Subject: Response to Submissions request for comment – 200 Aldington Road, Kemps Creek (SSD-10479)

Attachment A – EES comments on Response to Submissions for 200 Aldington Road Industrial Estate (SSD-10479)

TYPICAL SECTION BIO-RETENTION BASIN A

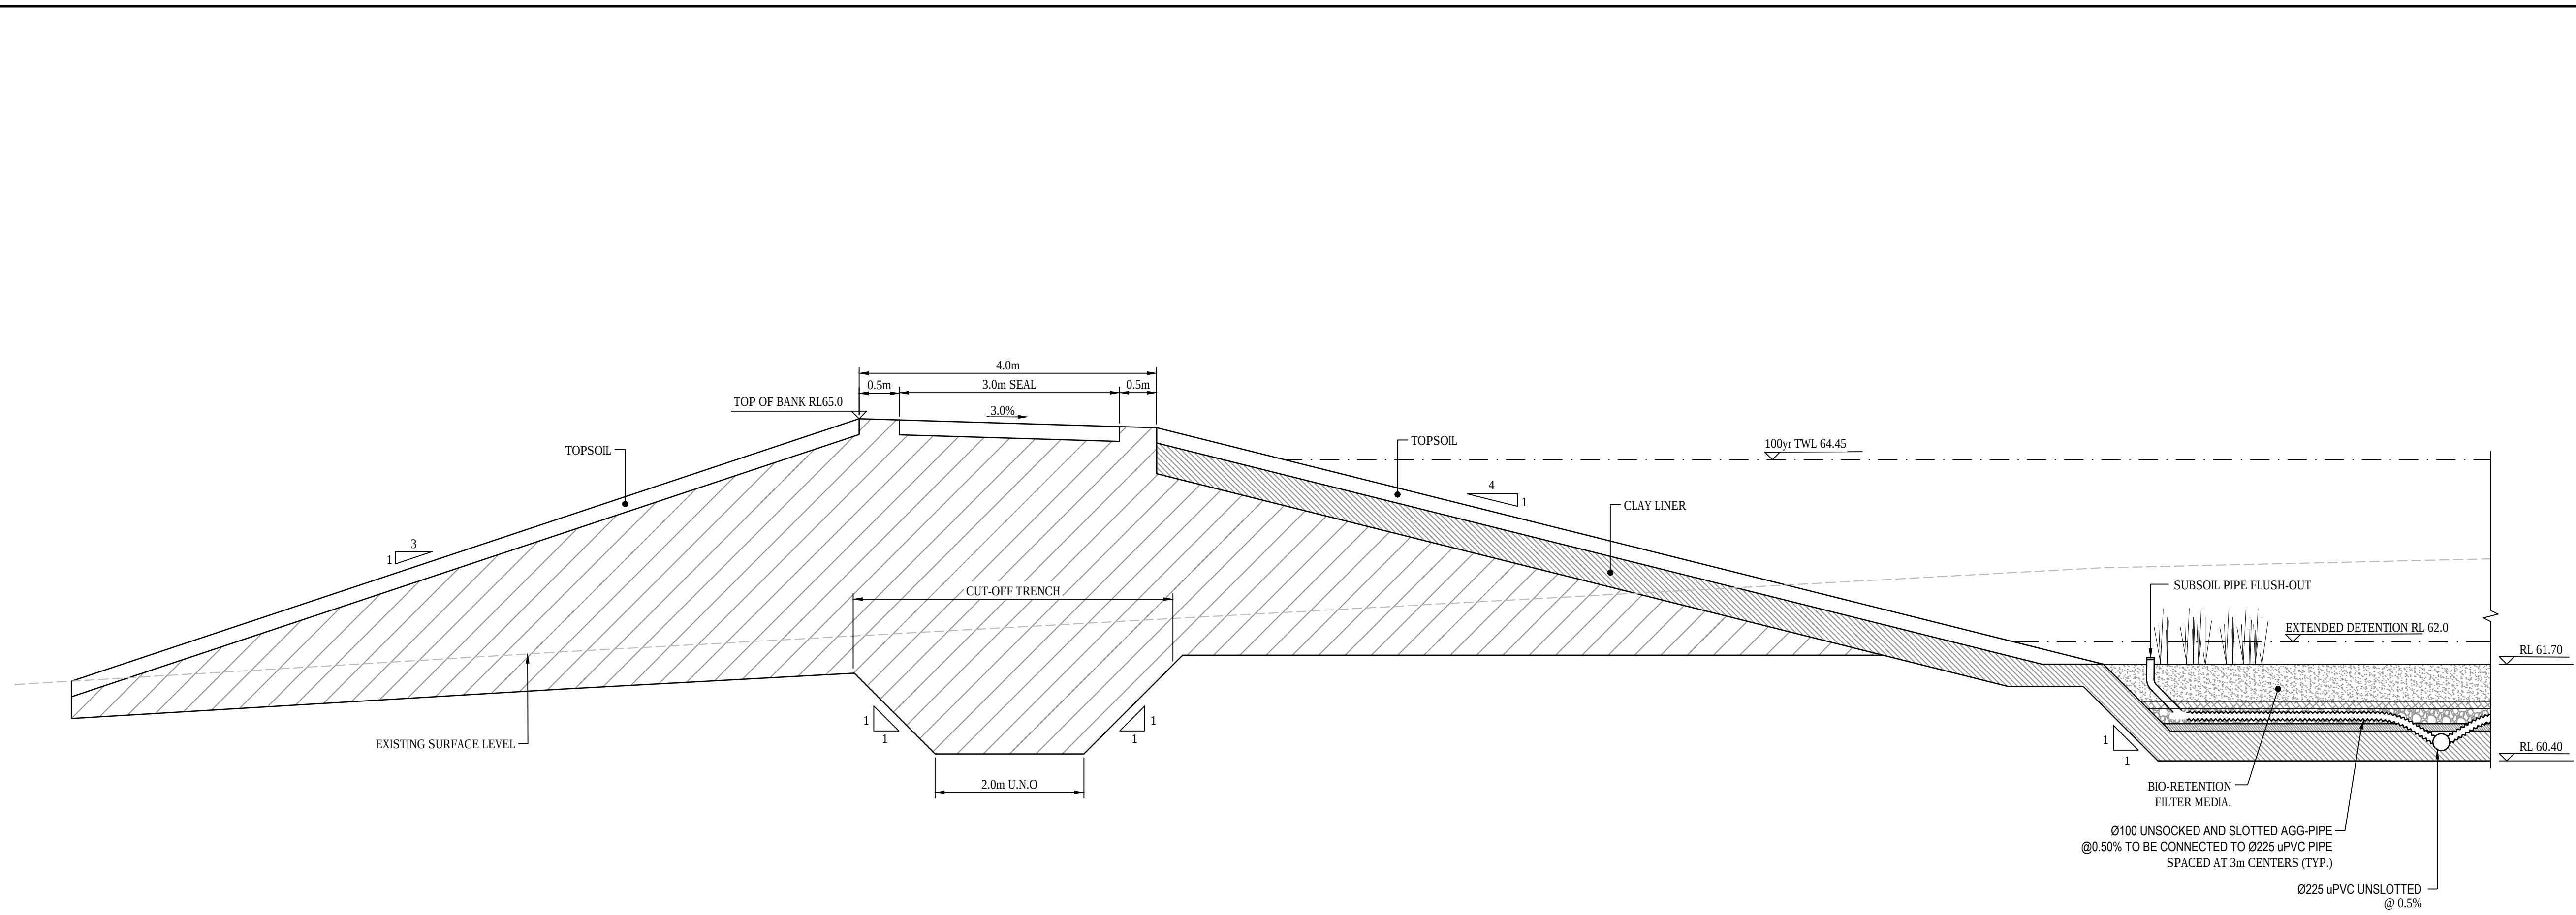
This has not been adequately addressed. In accordance with section 8 of the BAM, more information is needed to document and justify the location and design of the project, particularly in relation to the location of the proposed bio-retention basin in the north eastern corner of the site. This basin will remove a portion of the endangered Swamp Oak floodplain swamp forest, which forms part of, and is contiguous with, the riparian vegetation in the proposed VMP area.
